April 14, 2022

**Re: Albuquerque Ranch Phase 2 - 12501 Walkerway St. NE
Erosion and Sediment Control Plan
Engineer's Stamp Date (4/8/2022) (E22E002)**

# TESCP

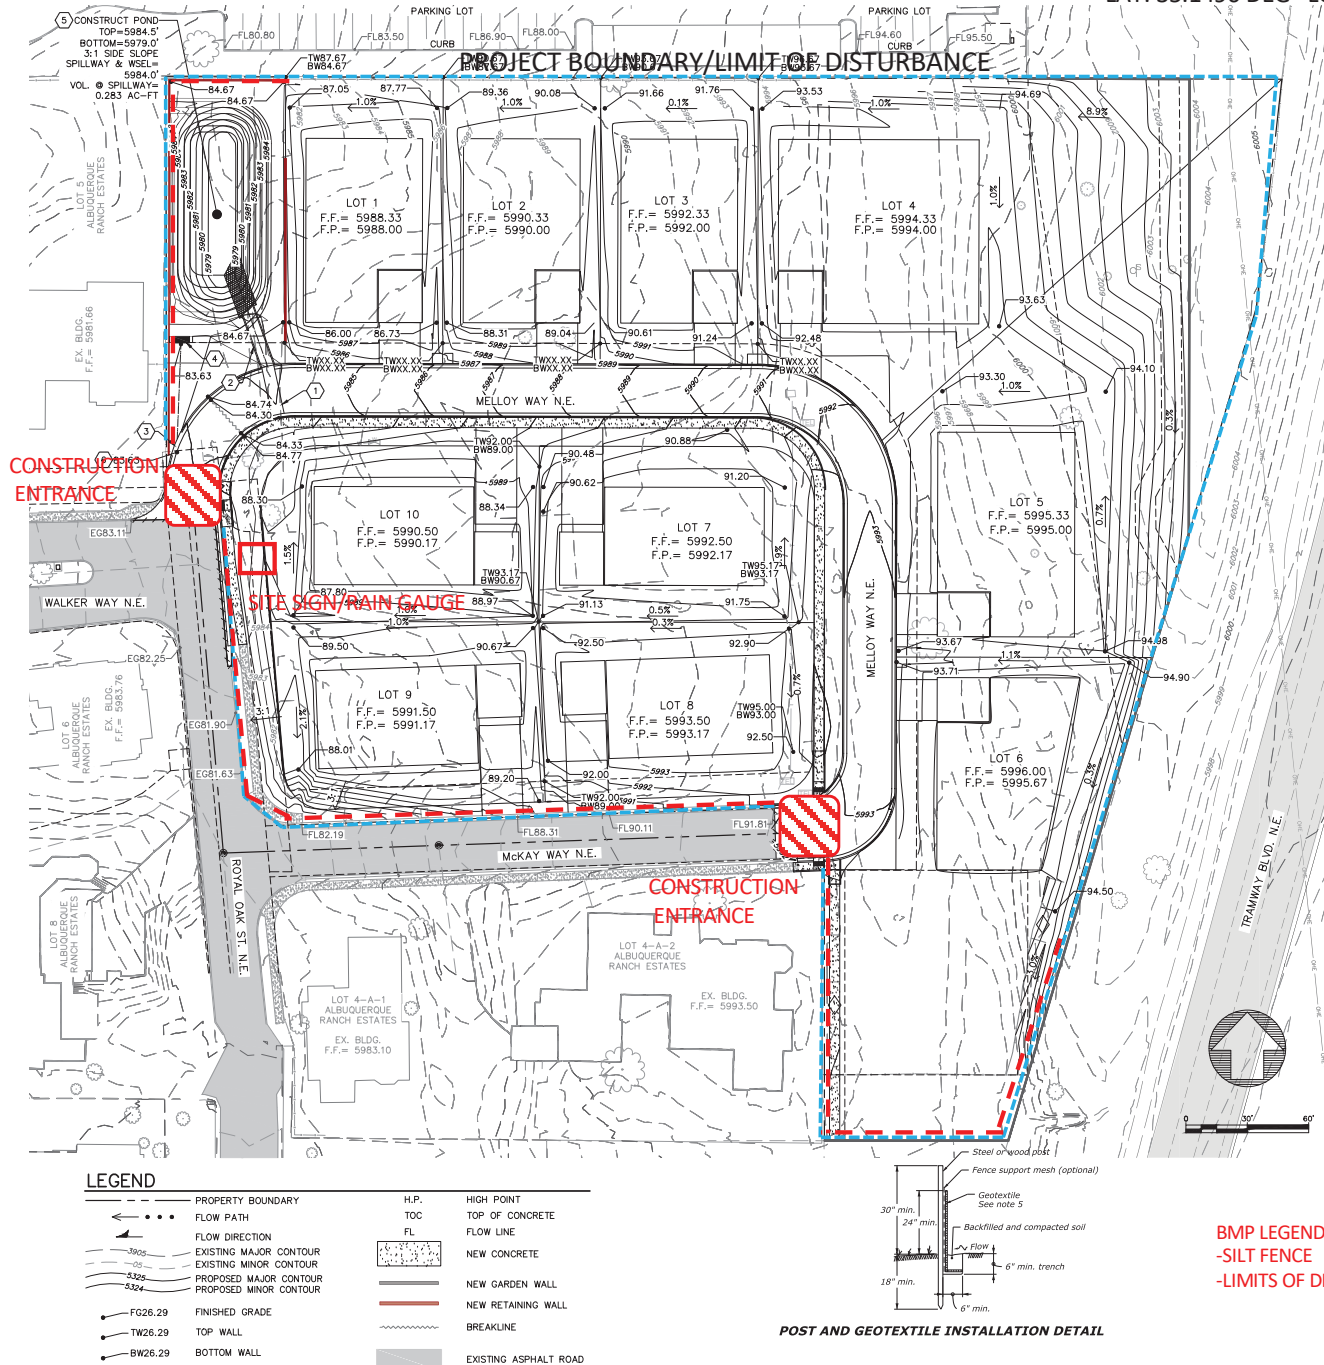
The following comments must be addressed prior to ESC Plan approval for Work Order.

1. Revise the description of the nature and extent of construction activities (CGP 7.2.2.a) and a Project Schedule (CGP 7.2.3.f) or Sequence of Construction. Delete references to vertical construction, since this operator will only be responsible for demolition, grading, and infrastructure construction. Identify separately the areas that will be stabilized by this operator and the areas that will remain disturbed when transferred to separate operators for construction. BMPs to keep sediment from the lots out of the streets after they are built, and transfer of the lots to the home builders (instead of stabilization).
2. The ESC Plan can't be approved for Work Order until the final G&D Plan is approved by Hydrology for Work Order. So far they have only approved a preliminary plan for DRB and rough grading.
